Application # 0750018564

COUNTY OF HARNETT LAND USE APPLICATION

PROPERTY LOCATION: Subdivision: NA HIVE Lot #: 30 Lot Size: .86

SITE PLAN APPROVAL

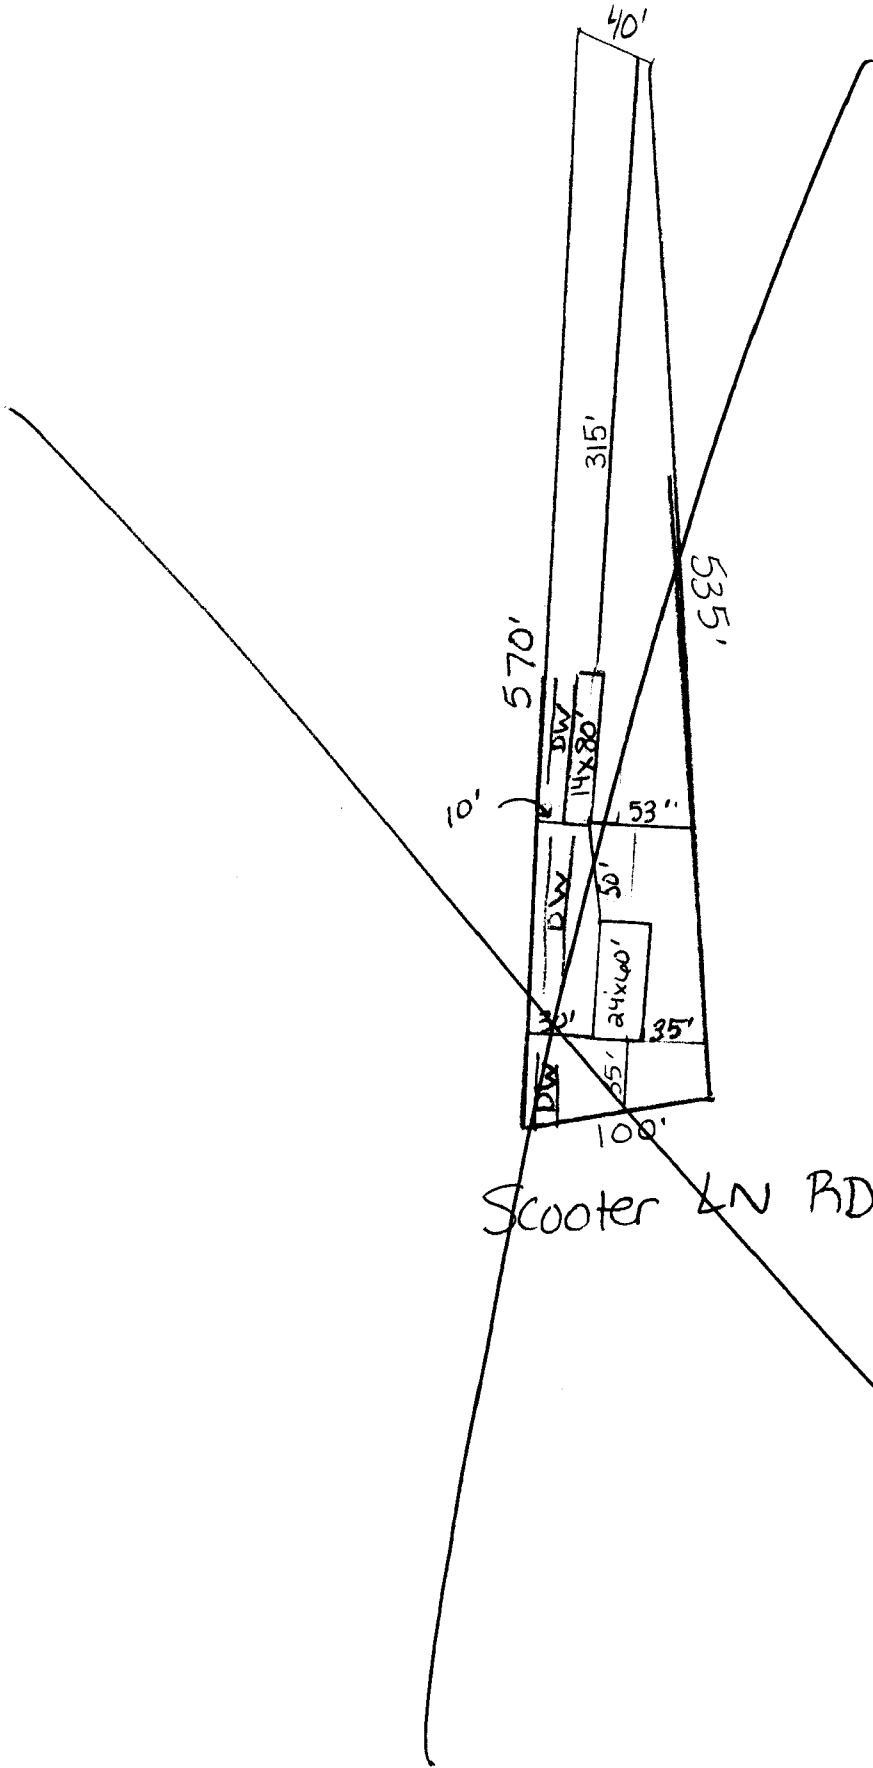
Appears

that line from

existing tank runs

under PP MK site (cannot build or place here
on top of drain lines)

In order to tell how down

pipe all come out of tank

2 "D" Box if one is then can

Determine by probe which way

lines run. After that

we can figure ~~where to~~ if it possible
